From: Amanda Scholes on behalf of Planning.Responses
Sent: 10 November 2021 08:32
To: Planning Scanning
Subject: FW: Y/123/21/PL - Land to the south of Ford Lane and East of North End Road, Yapton
Attachments: A958_01E_PLANNING LAYOUT COLOUR NO SCHEDULE.pdf; A958_01E_PLANNING LAYOUT NO SCHEDULE.pdf
Importance: High

From: Sue Howell <[REDACTED]>
Sent: 09 November 2021 16:42
To: Michael Eastham <[REDACTED]>
Subject: FW: Y/123/21/PL - Land to the south of Ford Lane and East of North End Road, Yapton
Importance: High

I have received the updated site layouts showing some estate railing around the turning head. Please see attached. I am still waiting for the updated Landscape Management Plan which will also reflect this change. This drawing should follow on later this afternoon.

Title:
PLANNING LAYOUT

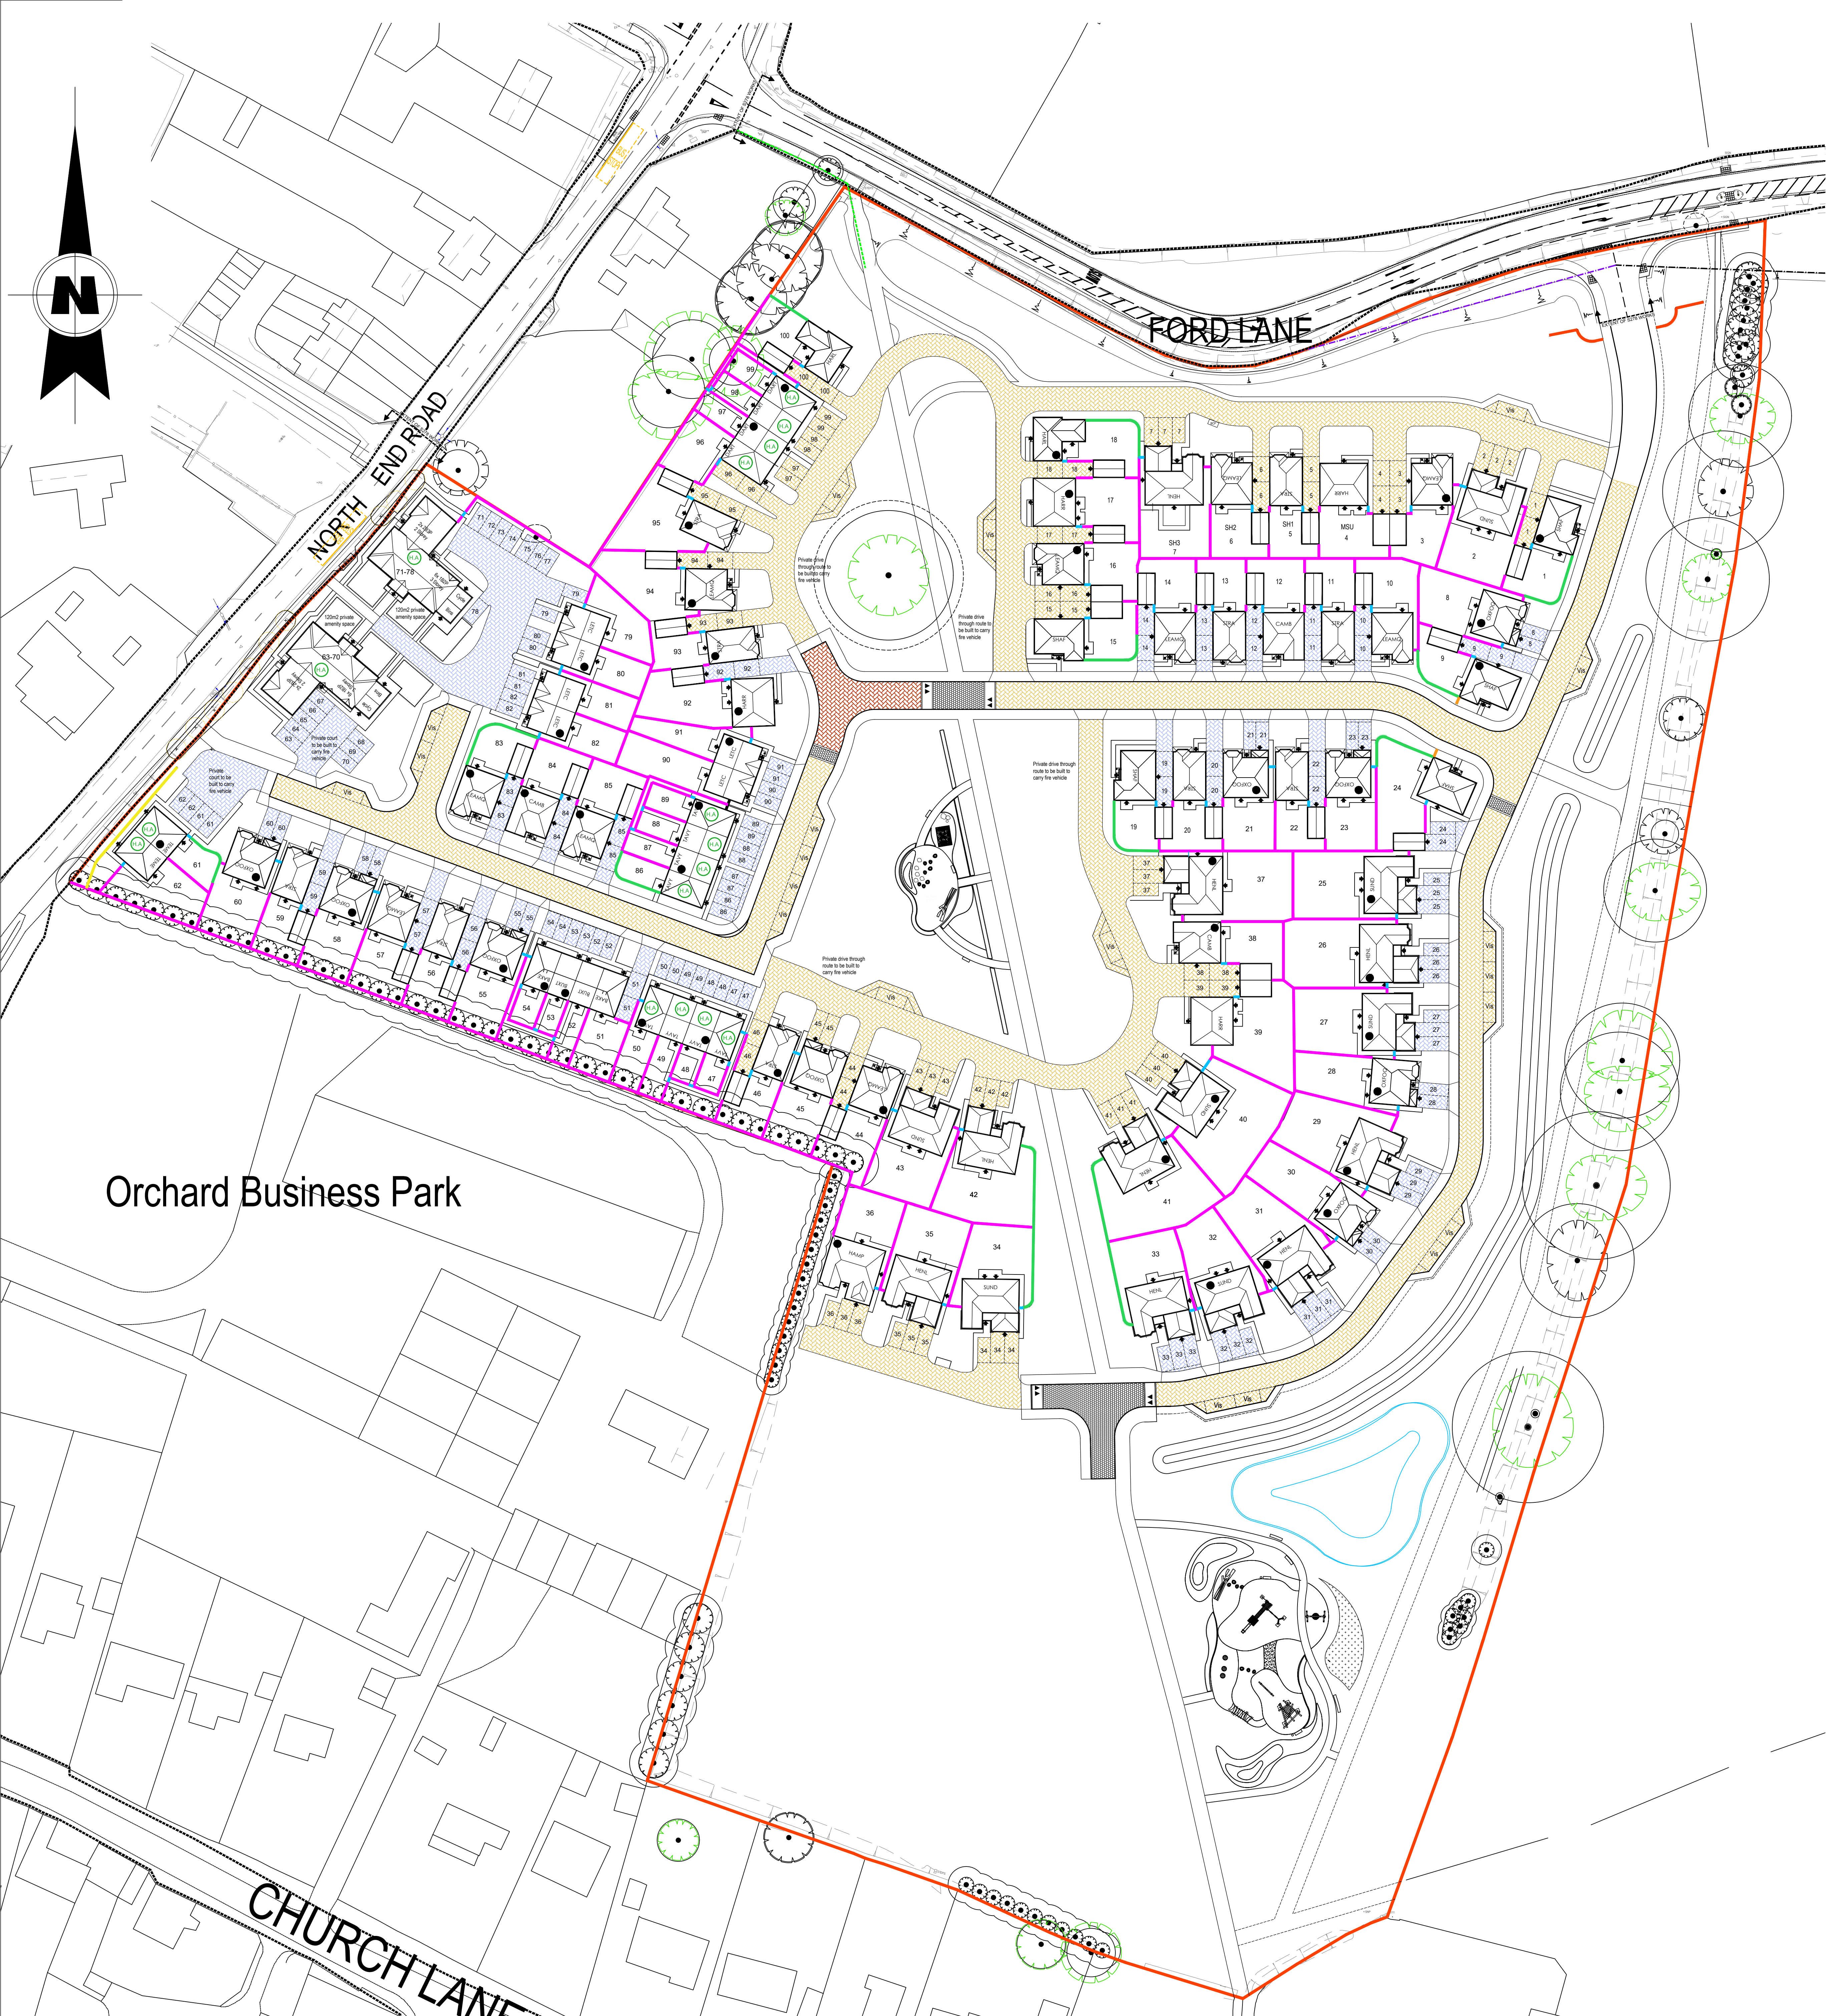
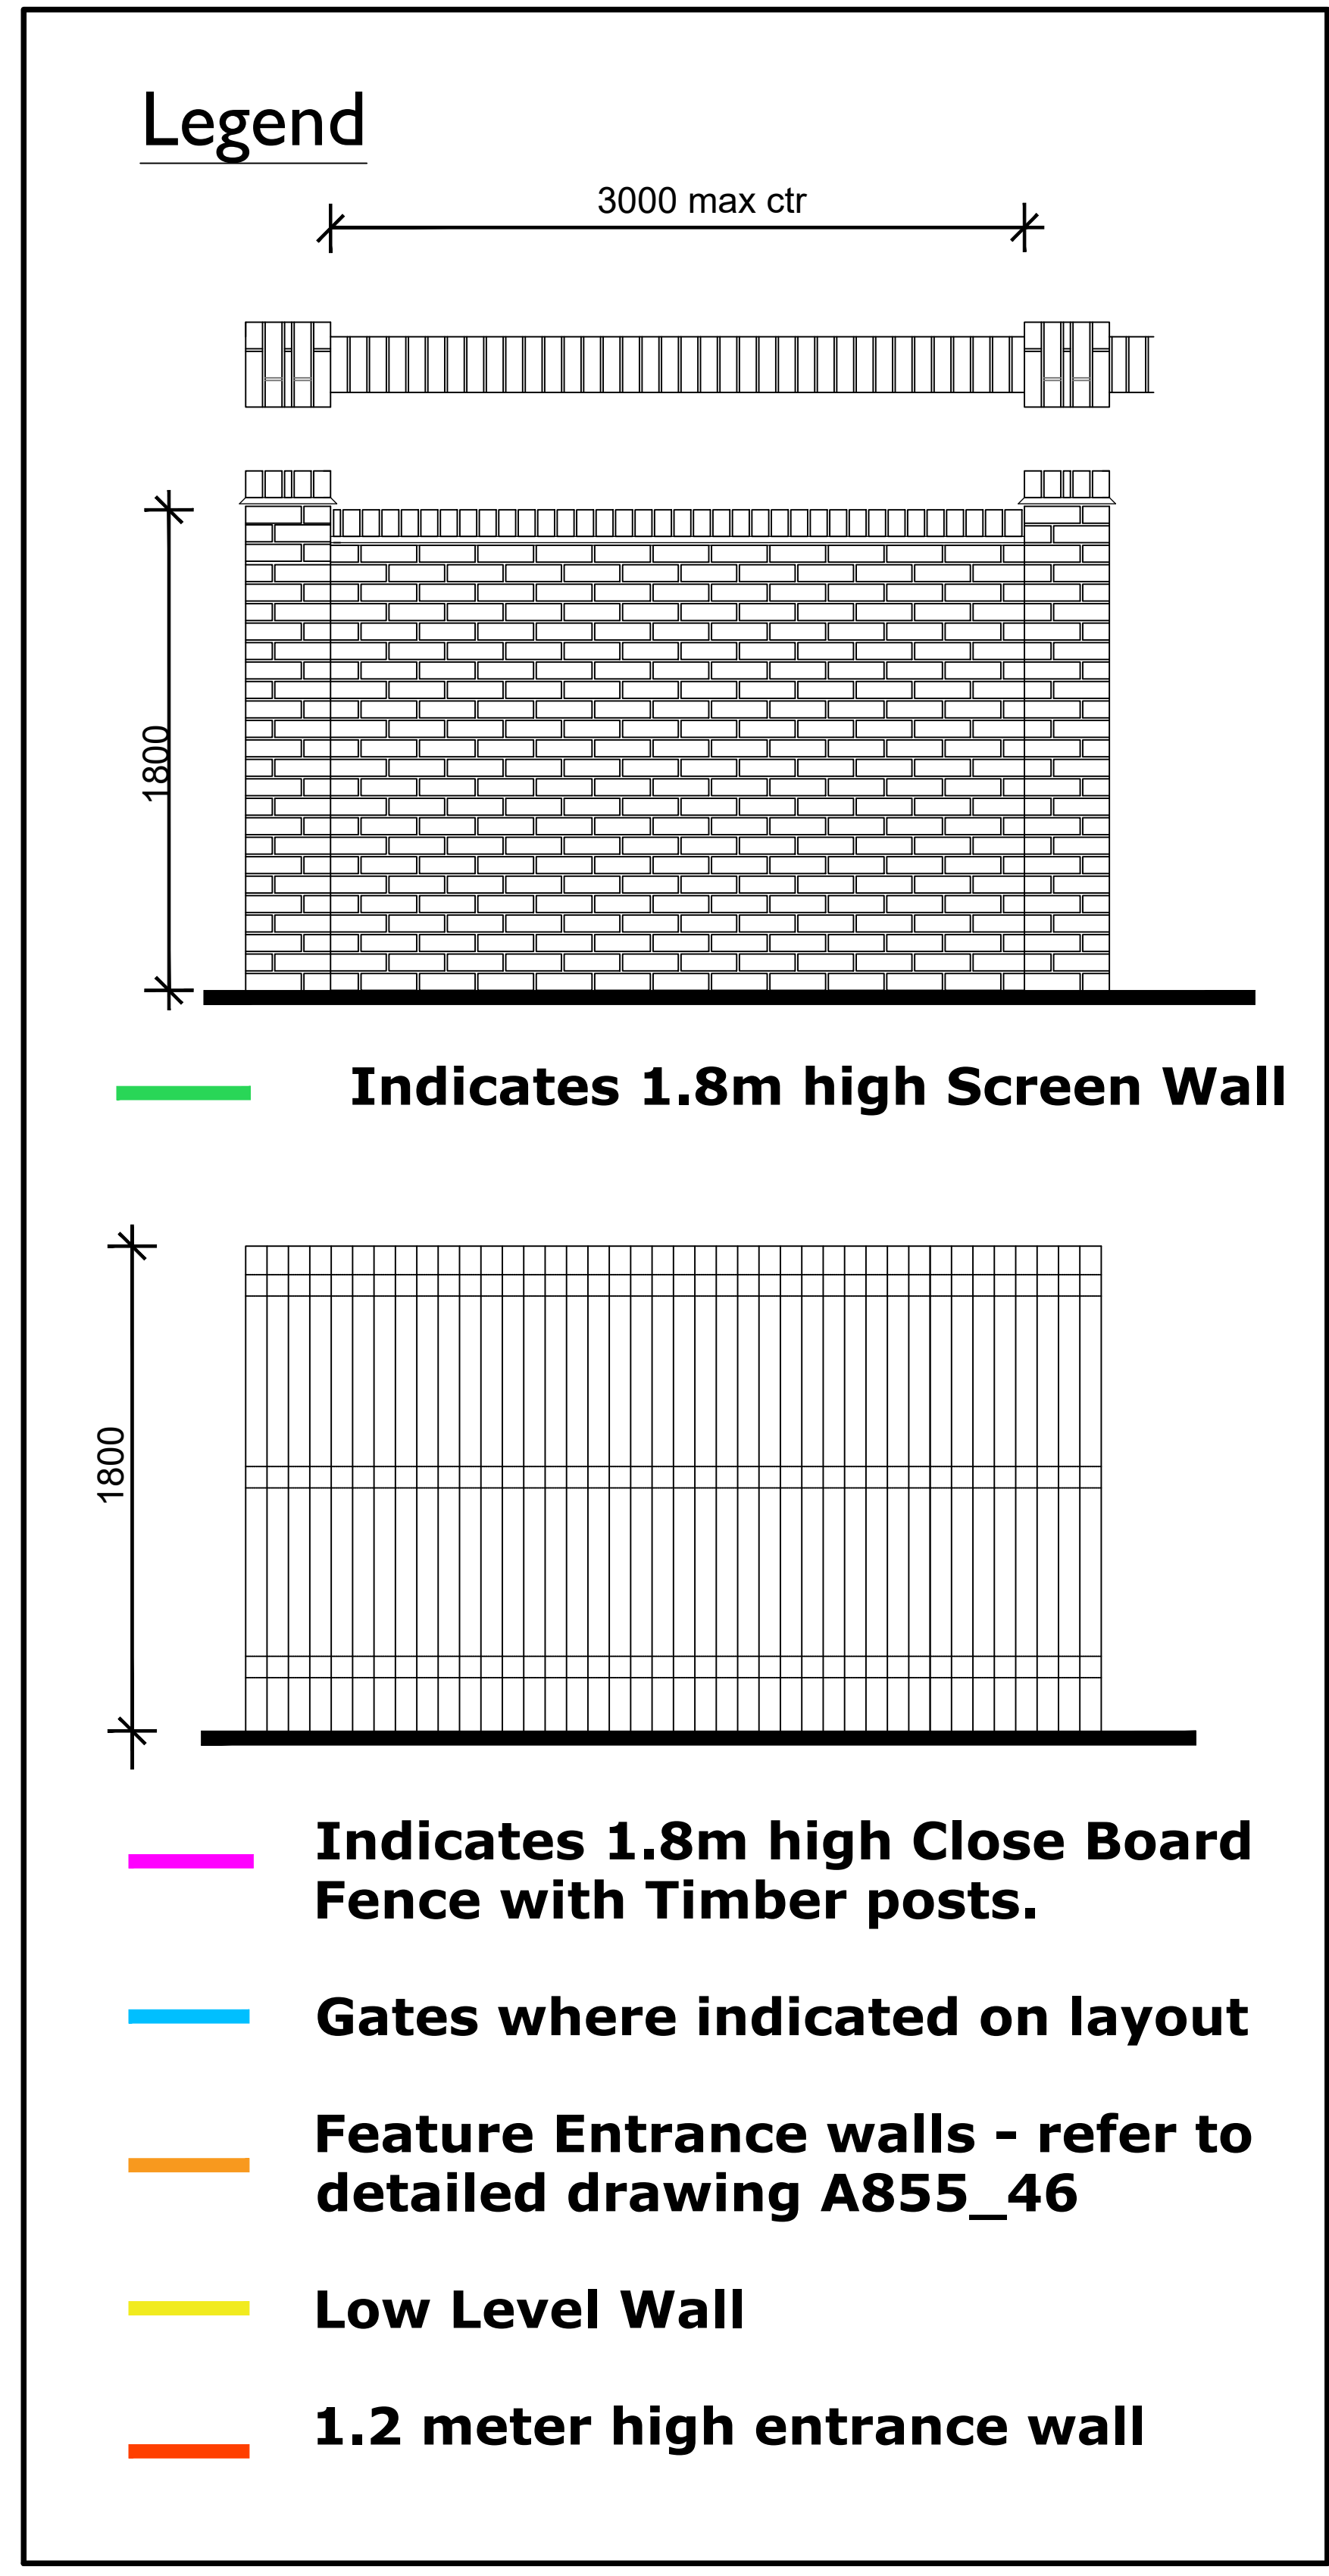
To protect this area would appear a sensible option and fencing could be used to tie in with the bunding to the east and west to help prevent unauthorised access onto the POS.

The alternative to this and **my recommendation would be just to extend the bunding in the same location as the shown fencing** (fencing can be chain sawed off at ground level so bunding would be potentially a more secure option) bunding when seeded would be less obtrusive and would tie in with the already proposed bund as shown.

Either would work assuming access not required for maintenance machinery off the turning head when in fact a gate would then be required rather than just post and rail fencing?
